Appeal Decision

Appeal Ref: APP/R5510/W/22/3310696

1A Roseville Road, Hayes, Middlesex UB3 4QX

- The appeal is made under section 78 of the Town and Country Planning Act 1990 against a refusal to grant planning permission.
 - The appeal is made by Mrs Narinder Singh against the decision of London Borough of Hillingdon.
 - The application Ref 1142/APP/2022/697, dated 30 January 2022, was refused by notice dated 7 July 2022.
 - The development is change of use from 6 person HMO to 9 person HMO.
-

1a Roseville Road Hayes UB3 4QX

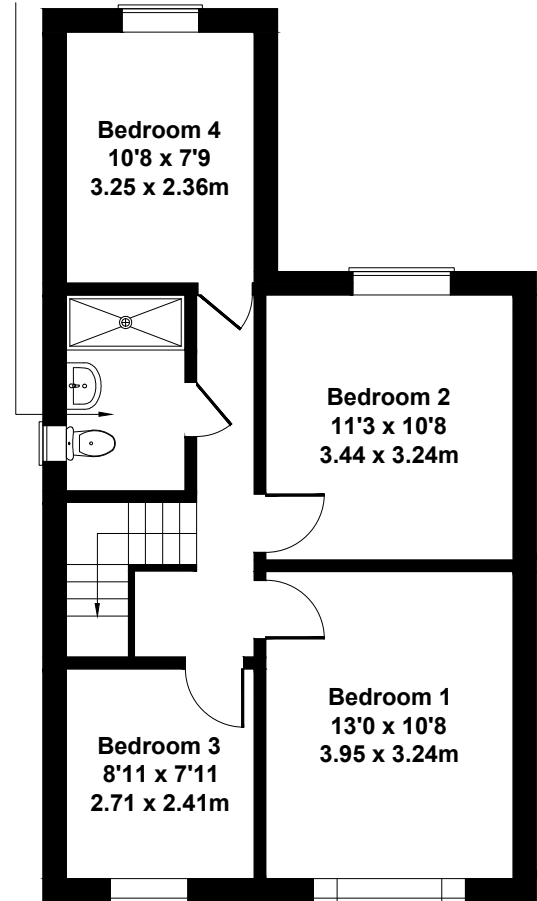
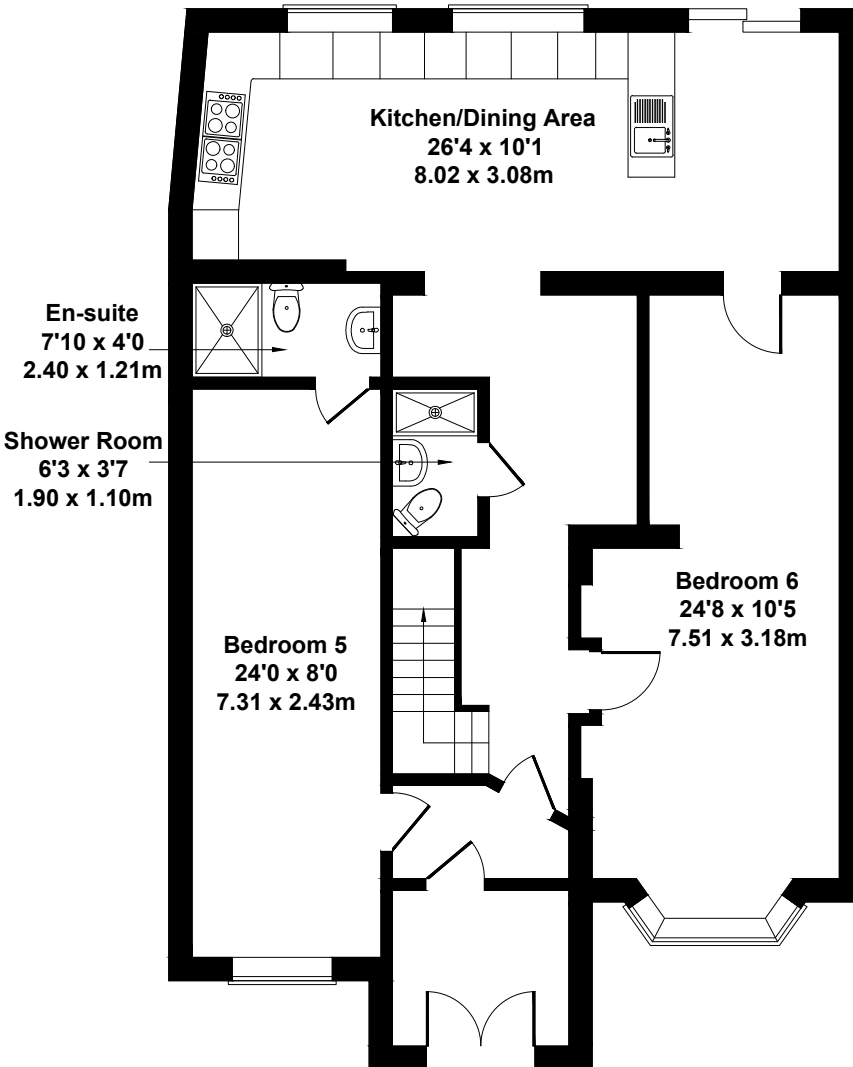
13. The proposed development provides 6 bedrooms, a communal kitchen and dining area. The internal layout would essentially remain unchanged, and the kitchen area would be the only internal communal space for residents to spend time for meals, recreational activities or home working.

14. Taking into account the number of residents proposed the kitchen and dining area would be a cramped and uncomfortable space especially during meal times. Furthermore, recreational activities and the potential need for some residents who may work from home would magnify this discomfort. Due to the cramped communal internal space the proposed development would result in a substandard form of accommodation.

16. The Council contend that there would be a shortfall in the quantum of external amenity space. This is not disputed by the appellant. I acknowledge the presence of open green spaces nearby, however, in my view, this does not compensate for the lack of provision of external amenity space proposed.
